From: Gregg, Robert <Robert.Gregg@lancashire.gov.uk>
Sent: 05 September 2018 08:47
To: Stephen Kilmartin
Cc: planning
Subject: APP. 3/2018/0696 - CALDING BANK COTTAGE, BILLINGTON

The proposal for the demolition of an existing garage and the erection of a guesthouse and swimming pool.

Project					
Calder Bank Cottage, Whalley Old Road, BB7 0JE					
Drawing Title					
Proposed Site Plan					
Drawn	Checked	Paper Size	Scale	Date	
PL	PL	A3	1:200 @ A3	JULY 2018	
Project No.		Drawing No.		Revision	
18 - 262		005		C

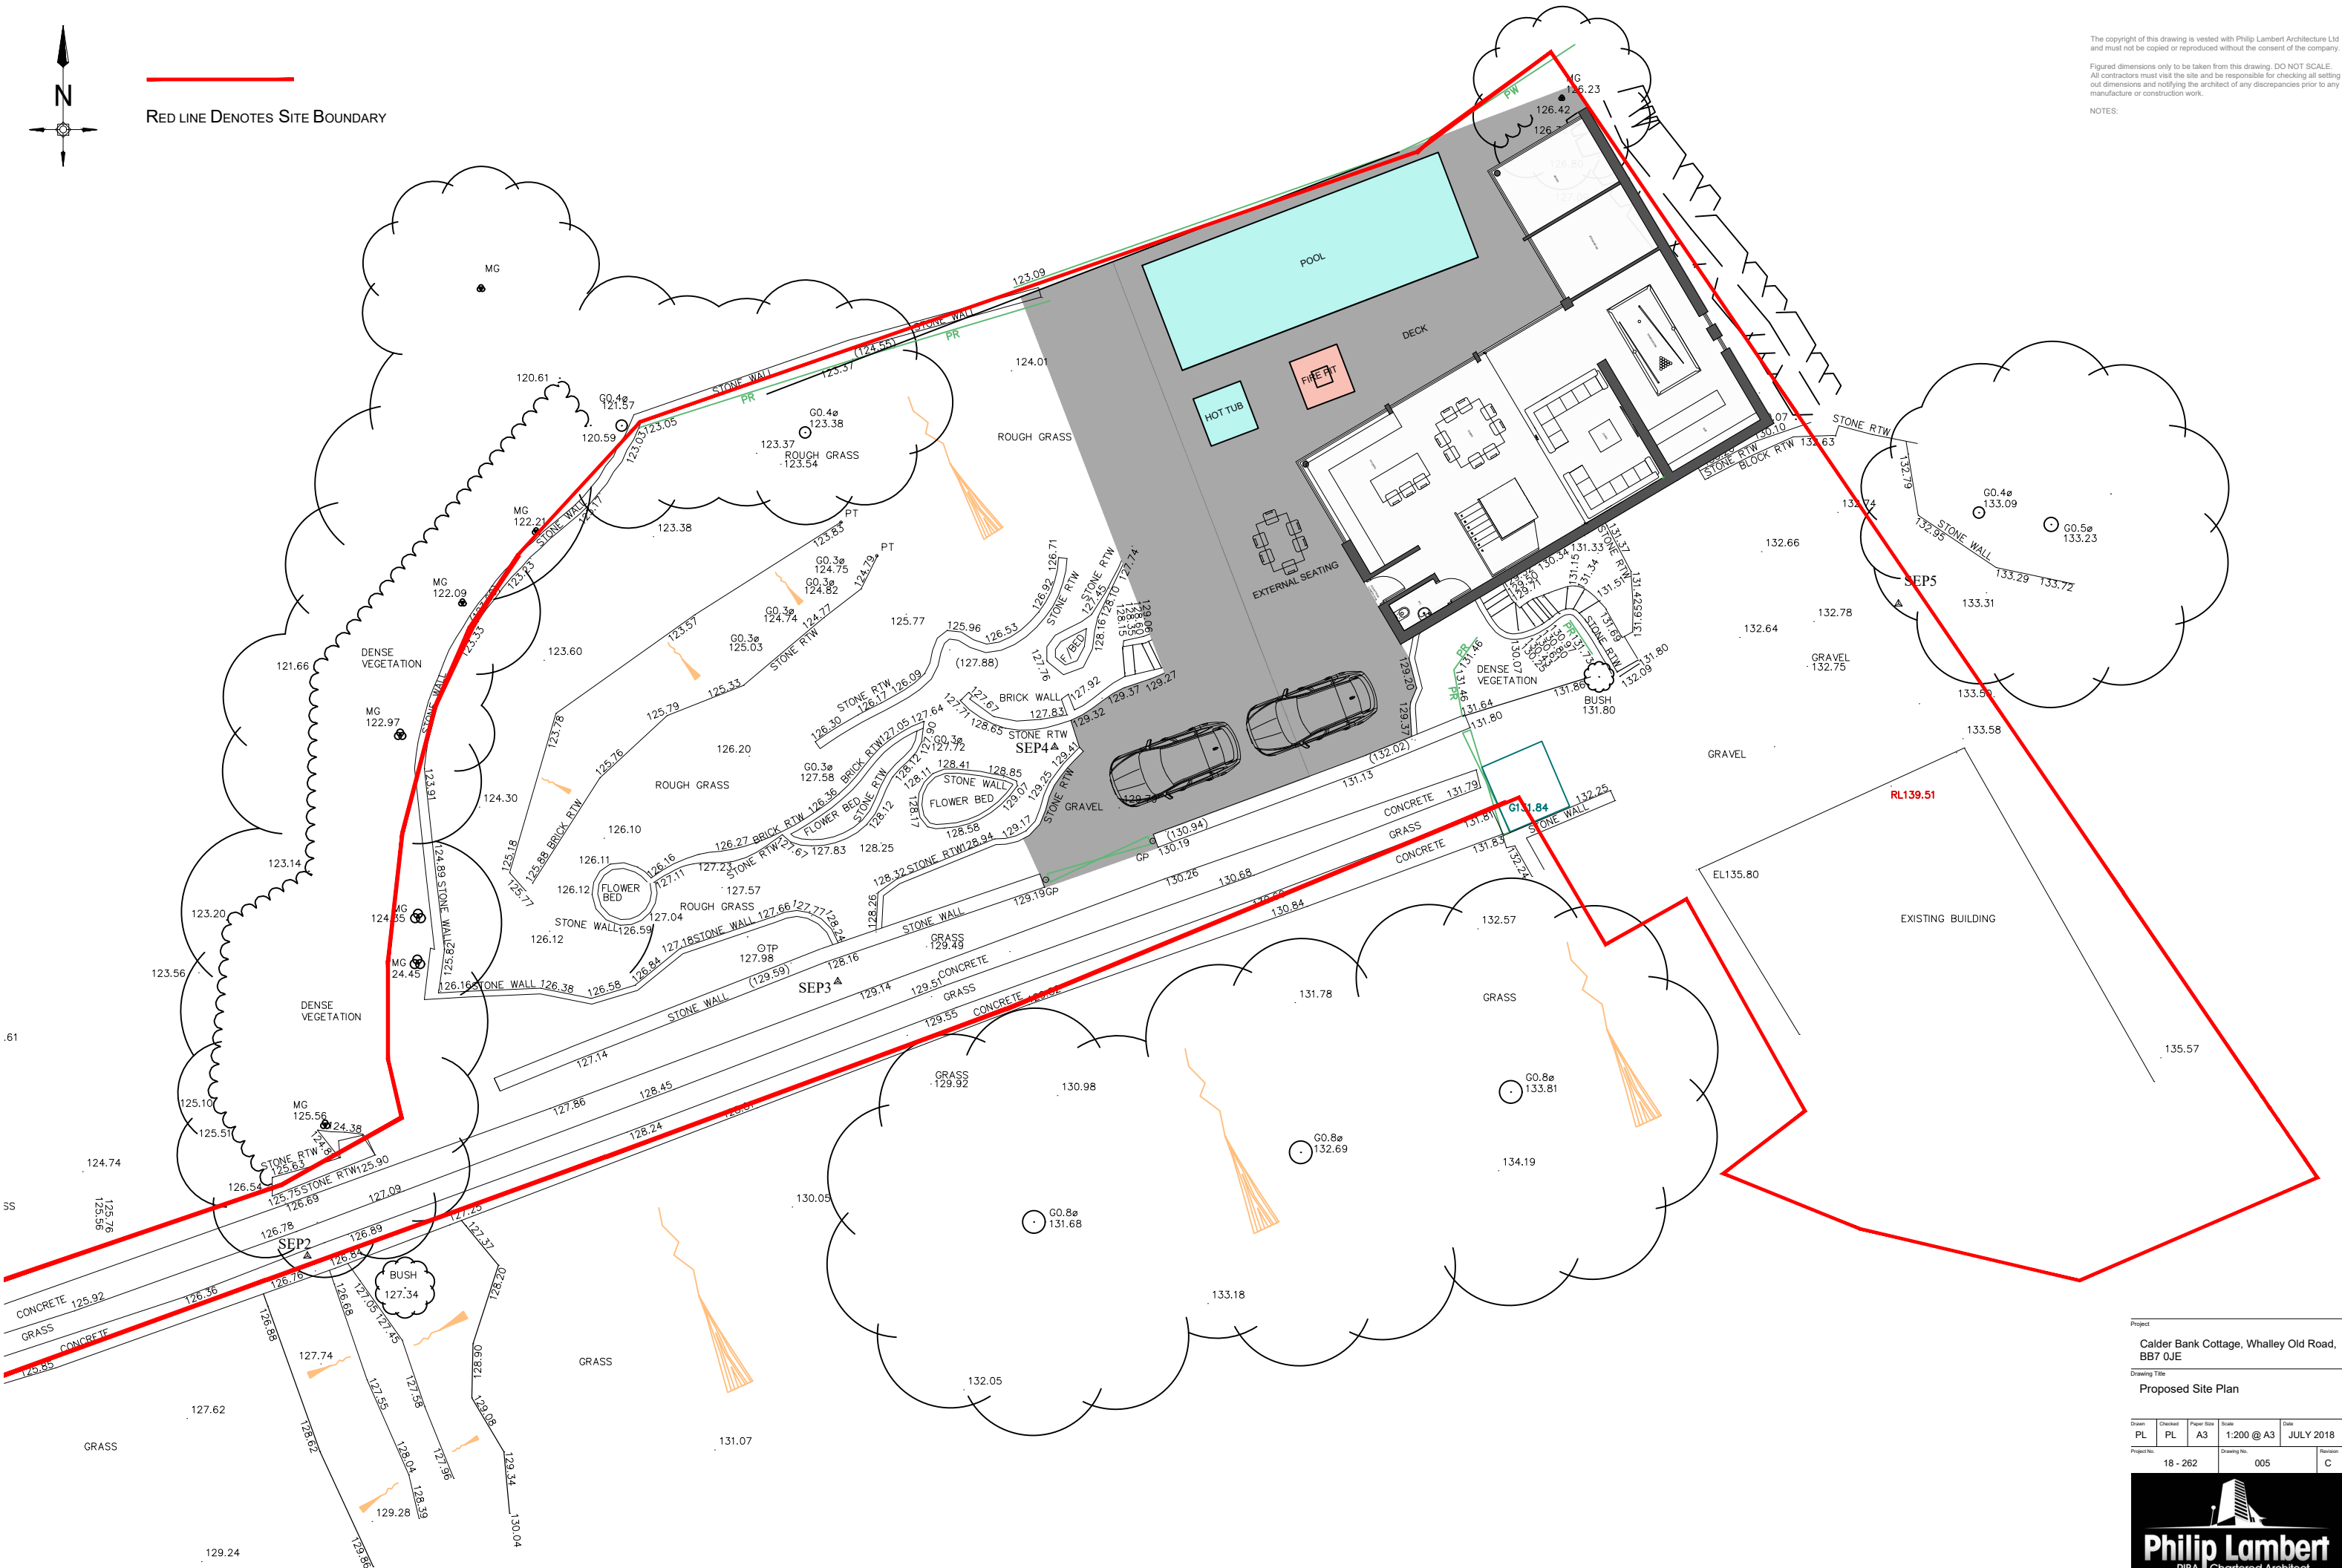
I would require clarification on whether the guesthouse would be either an operational functioning business or a residential dwelling as parking standards differ between the two. I would also require further information on the further two existing property's adjacent to the proposal in respect of their required parking provisions.

My concern would be that as a result of this proposal the demolition of the existing garage would restrict the prior parking arrangements for Calding Bank cottage.

I would need to see a revised plan which would indicate the overall parking arrangements for the proposed guesthouse along with the two existing dwellings.
